City of Portland, Maine - Building or Use Permit Application

Permit No: 04-0844	Issue Date: JUL 19 2004	CBL: 029 0002001
-----------------------	----------------------------	---------------------

This is to certify that 164 Realty Llc/Maine Property, Inc.
has permission to build counter,shelves, add window
AT 164 Middle St 029 0002001

Proposed Use: sandwich shop/deli	Proposed Project Description: build counter,shelves, add window
--	---

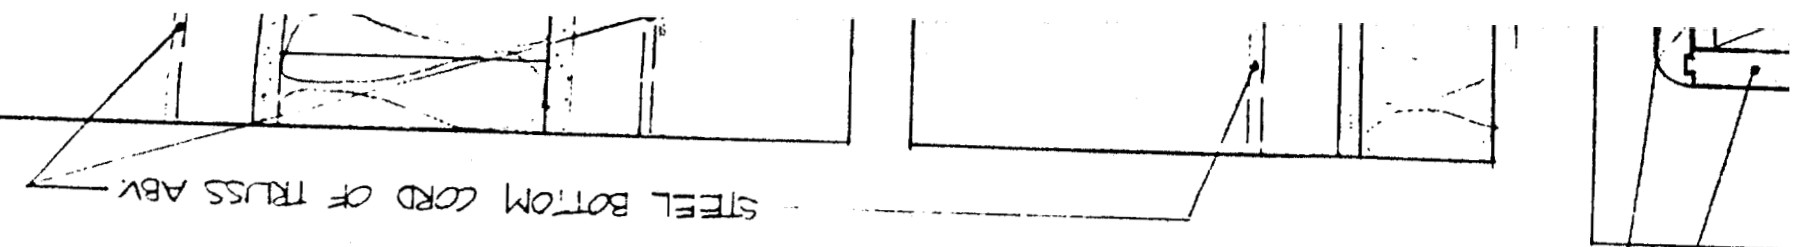
- 1) * Window to be 1/1 double hung bronze aluminum-framed window. Window to fill the entire vertical opening as shown on the submitted photo, which shows the facade prior to application of dryvit. (See marked-up copy of photo attached).
- * Window to be recessed and surrounding dryvit to be finished similar to treatment of windows on abutting dryvit-sheathed party wall.
- * Window supplier to verify dimensions and placement of window with HP staff prior to installation.

# Fitt to Eat.

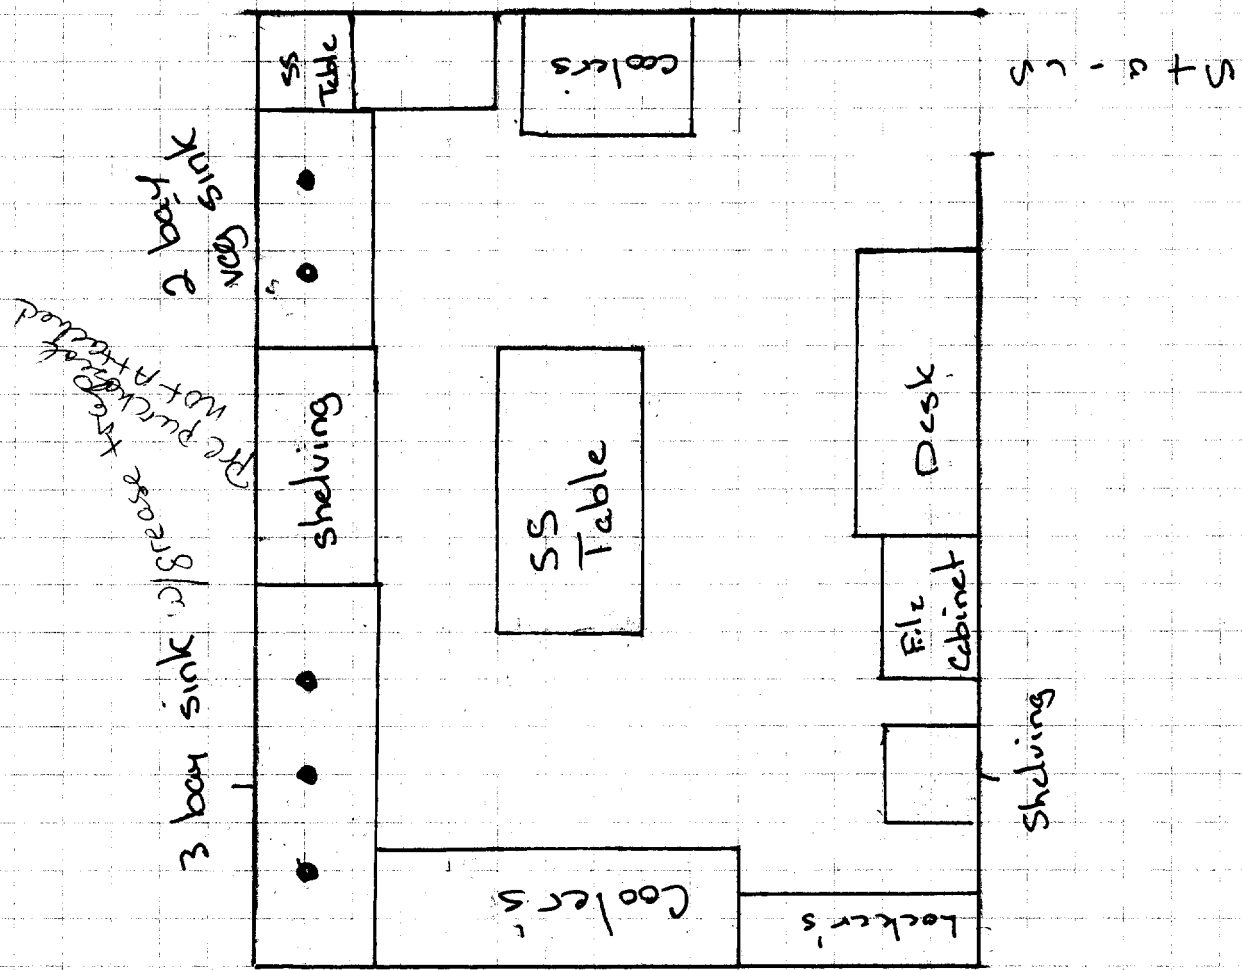
- 1) No customer access is allowed in the "mezzanine"
- 2) Food prep limited to equipment as show on the plans, no open stoves, grills, fryolators or similar are allowed as there is no local exhaust system.
